Re: Sunset Apartments
SE Corner of Sunset and 82th St.
Traffic Circulation Layout
Engineer's Stamp 09-13-22 (L10-D032)

Based upon the information provided in your submittal received 09-15-22, the above referenced plan cannot be approved for Conceptual TCL until the following comments are addressed:

SUNSET APARTMENTS
ALBUQUERQUE, NM
TRAFFIC CIRCULATION LAYOUT

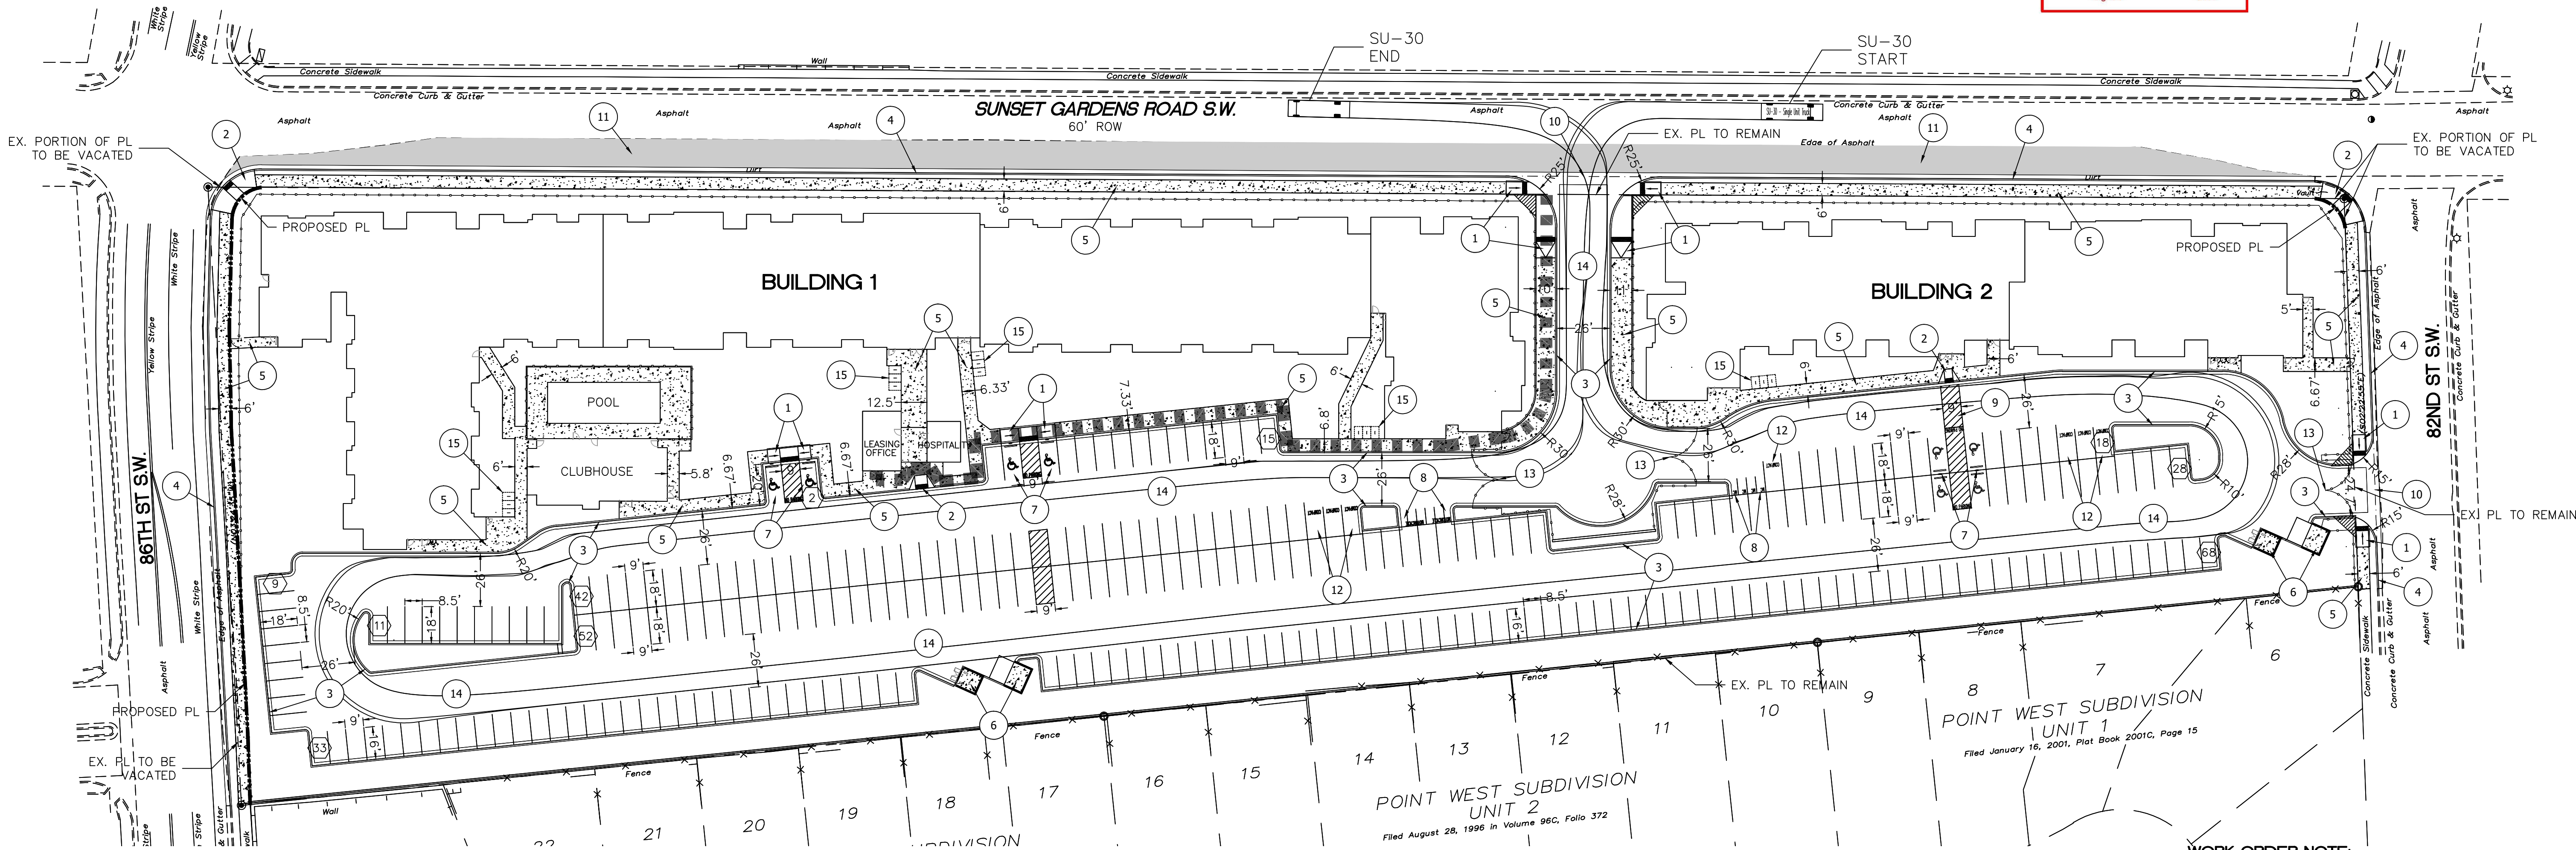
1. Please show the North Arrow on the site plan.
2. Clarify existing property lines and proposed property lines.
3. The ADA accessible parking sign must have the required language per 66-7-352.4C NMSA 1978 **"Violators Are Subject to a Fine and/or Towing."** Please call out detail and location of signs.

4. The ADA accessible spaces must include an access aisle. Van accessible aisles should be 8ft wide; all others should be 5ft wide.
5. Please provide details for all proposed pavement marking and signs (ADA and Motorcycle parking spaces).

6. Provide the width for driveway access off 82th st.
7. Key note 10: please reference COA std dwg 2426 for the proposed driveways accesses.
8. Key note 5: please reference COA std dwg 2430 for the proposed sidewalk.

9. Key note 2: provide details and call out COA std dwg for the proposed ADA ramps.
10. ADA curb ramps must be updated to current standards and have truncated domes installed.

- 15. Per the IDO, a 6 ft. wide ADA accessible pedestrian pathway is required from the public sidewalk to the building entrances. Please clearly show this pathway and provide details.

- 16. Per DPM, a 6 ft. wide ADA accessible pedestrian pathway is required from the ADA parking stall access aisles to the building entrances. Please clearly show this pathway and provide details.

- 17. ADA accessible pedestrian pathway should not be placed behind parking space or adjacent to a vehicular way. Vehicle and pedestrian/wheel chair conflicts should be avoided as much as possible.

- 18. Define ADA pathways by labeling of ramps, flush pavement, dimensioning of pathways, doorways, etc.
- 19. All sidewalks along streets should be placed at the property line.

- 20. Parking areas shall have barriers to prevent vehicles from extending over public sidewalk, public right-of-way, or abutting lots.
- 21. Refuse vehicle maneuvering shall be contained on-site. The refuse vehicle shall not back into the public right of way. provide a copy of refuse approval.

- 22. Provide a copy of Fire Marshal approval.
- 23. It is not apparent what type of pavement surface is being proposed. A hard driving surface will be required as part of this proposed project for parking area and drive aisles.

BIKE RACK DETAIL

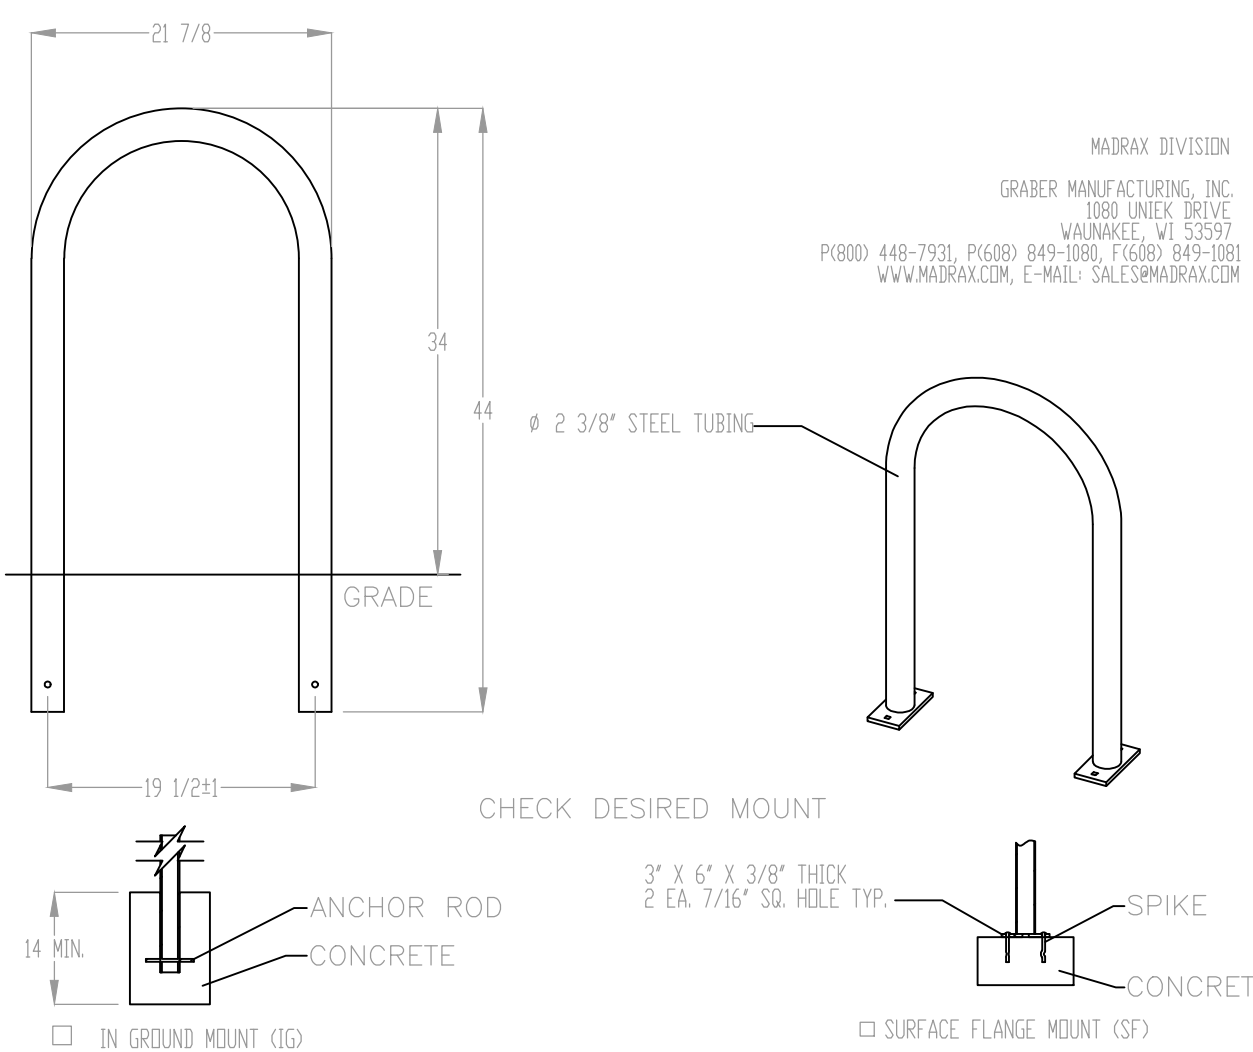
11. All bicycle racks shall be designed according to the following guidelines:
 - a. The rack shall be a minimum 30 inches tall and 18 inches wide.
 - b. The bicycle frame shall be supported horizontally at two or more places. Comb/toaster racks are not allowed.

- c. The rack shall be designed to support the bicycle in an upright position. See the IDO for additional information.
 - d. The rack allows varying bicycle frame sizes and styles to be attached.

- e. The user is not required to lift the bicycle onto the bicycle rack.
- f. Each bicycle parking space is accessible without moving another bicycle.
- 12. Bicycle racks shall be sturdy and anchored to a concrete pad.

- 13. A 1-foot clear zone around the bicycle parking stall shall be provided.
- 14. Bicycle parking spaces shall be at least 6 feet long and 2 feet wide.
